Our Case Number: ABP-319866-24

Re: Proposed development known as North Irish Sea Array ("NISA") Offshore Wind Farm
Located off the coast of Counties Dublin, Meath and Louth (www.northirishsearraysid.ie)

An Bord Pleanála,
Marine/Climate Section
64 Marlborough Street,
Dublin 1,
DO1 V902
07/08/2024

Figure 3.1 Overview of Indicative Construction Buoyage Area

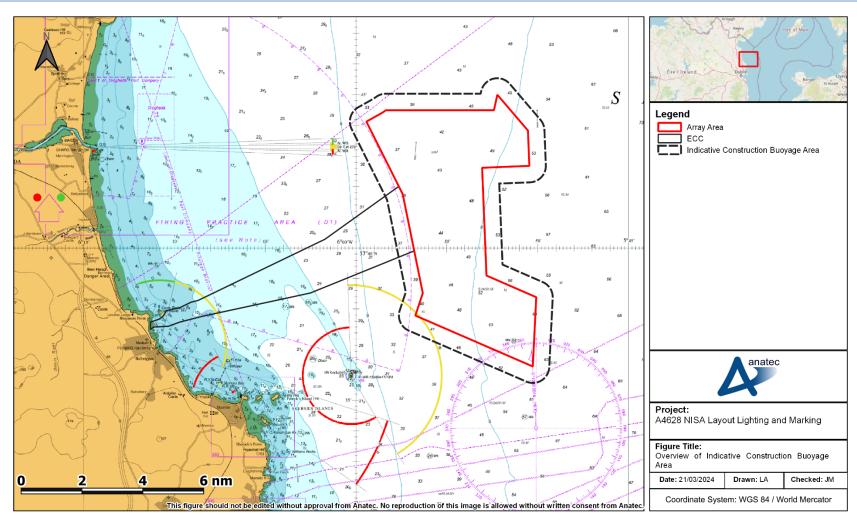
- h. During the construction and decommissioning phase, it is recommended that working areas be established and marked as appropriate. As construction areas become larger the spacing between marine aids to navigation and ranges of lights, need to be assessed so that it is readily apparent to the mariner that the AtoN are marking a zone.

Title North Irish Sea Array Offshore Wind Farm Lighting and Marking Plan

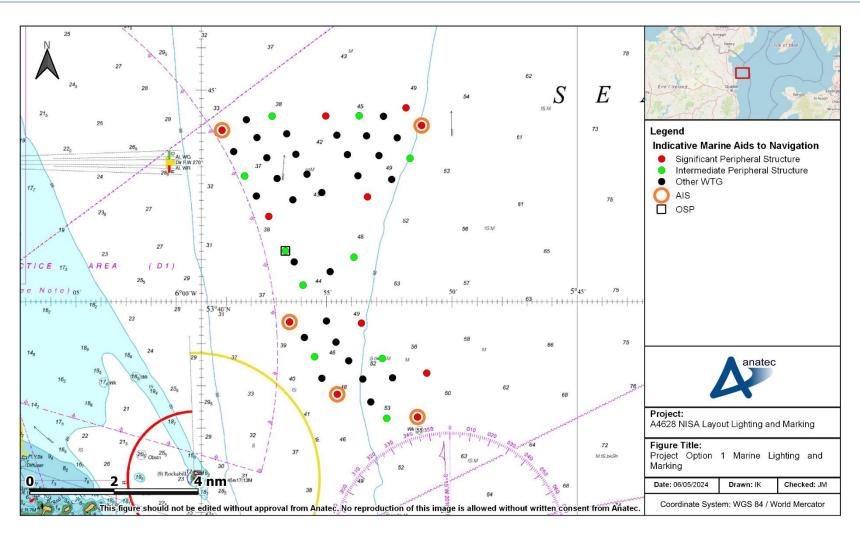
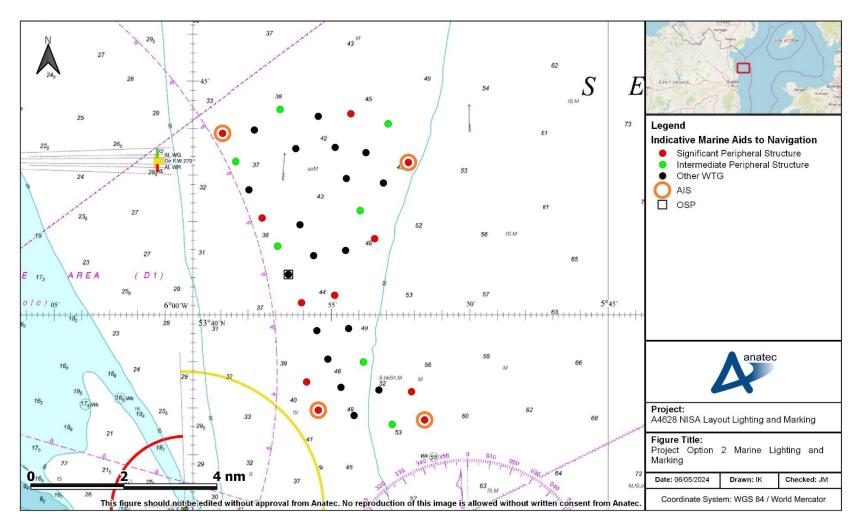
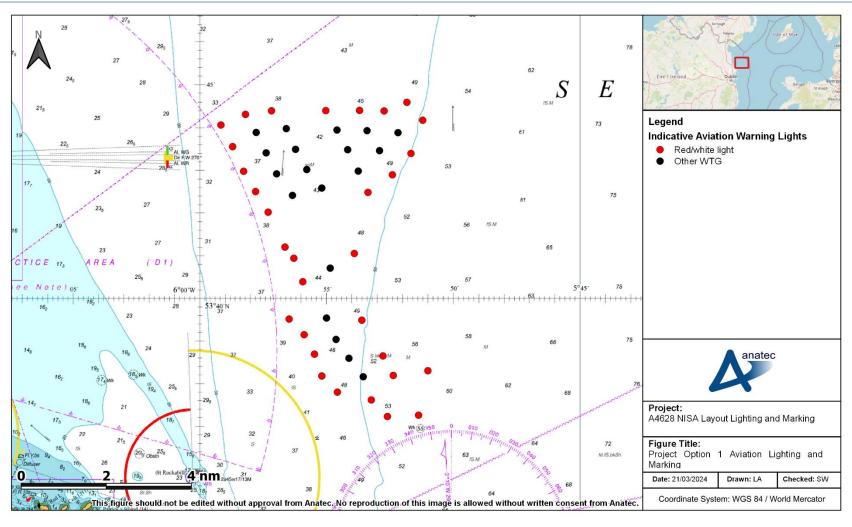
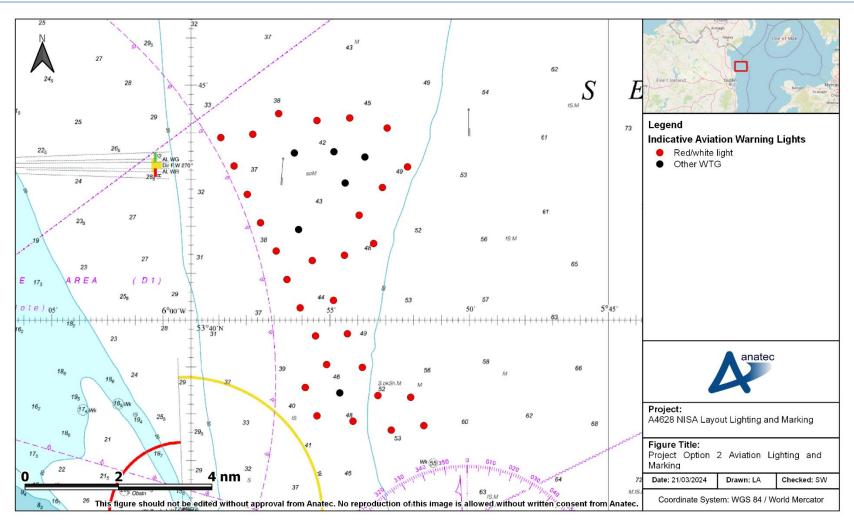
Irish Lights has been actively engaged with the North Irish Sea Array Offshore Wind Farm project team through several meetings prior to submission of the planning application. Earlier concerns regarding the site proximity to Rockabill Lighthouse and the potential for inadequate sea room for vessels transiting through this gap have been taken onboard by the project team. Irish Lights is now generally satisfied with the position, layout and proposed mitigation measures included in the development consent application documents. The draft Lighting & Marking Plan (LMP) is well considered and provides a good basis for refining the plan as the project proceeds and design options are finalised. Note that due to a typo in the EIAR report, Appendix 17.2 is titled "Vessel Management Plan" but refers to the Lighting & Marking Plan.

9. The Developer must, no later than 6 months prior to the Commencement of the Development, agree a Lighting and Marking Plan (LMP) with Irish Lights.
 - i. The LMP must make provision for amending the marking and lighting of the OSPs, as required by Irish Lights, in the event that any OSPs are constructed prior to the construction of WTGs within the Site, to ensure the marking and lighting of any OSP suits the layout of any surrounding WTGs that form part of any wind farm development located within the Site.
